Subject: Drove Lane Sales Cabin refs Y/141/21/PL and Y/142/21/A

I have today issued 21 day Neighbourhood Plan Notifications to you concerning these two applications. The applicants have made the following changes to the two applications:

Client: Barratt Southern Counties
Site: Ryebank Gate
Job No: Q80195 v9
Date: 19/11/2021
Designer: SM

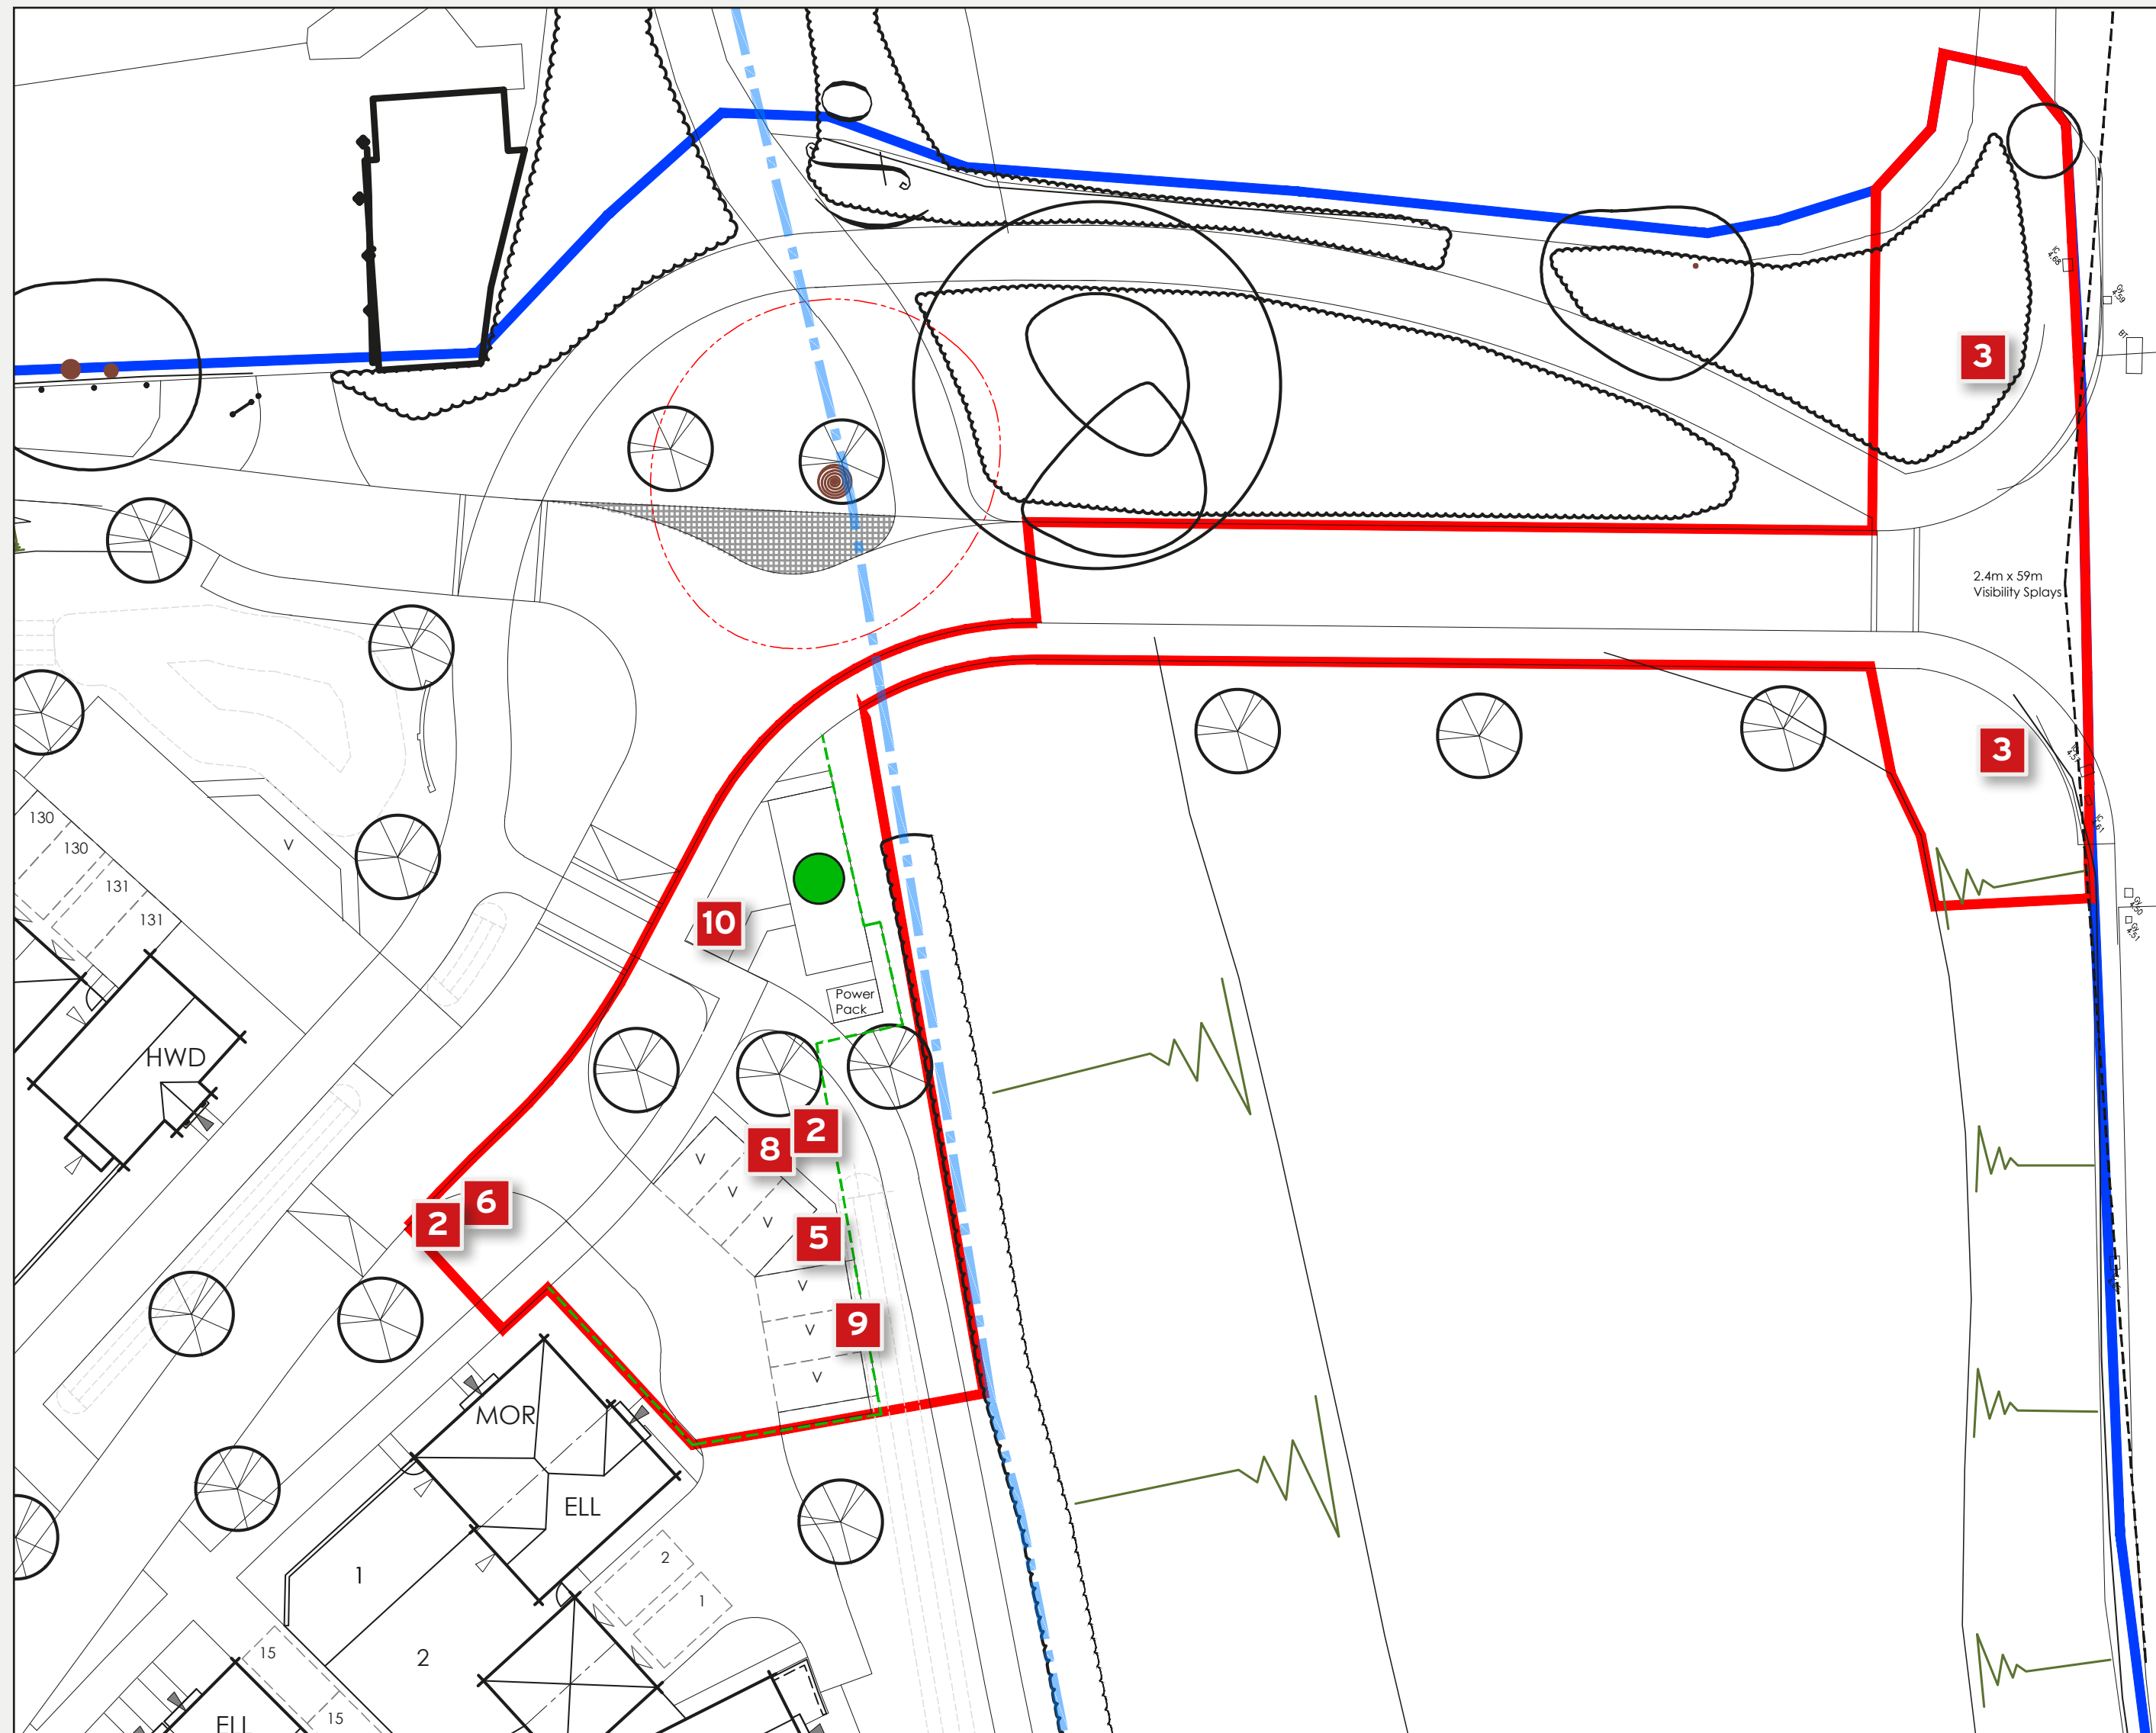
- Altered the siting of the Sales Cabin to allow more room for the existing footpath. This is in response to concerns from WSCC Public Rights of Way (who have also been reconsulted on this change);
- Updated the advertising plan to remove the 4 flag signs from the Main Road frontage instead having two totem signs in this location, one either side of Drove Lane. They have relocated two flag signs adjacent to the sales cabin away from the conservation area.

This meets with the Parish Council's earlier comments which stated that the number of static banner flag posts on the entrance of Drove Lane with Main Road should be reduced to no more than 2 advertisement signs of any size.
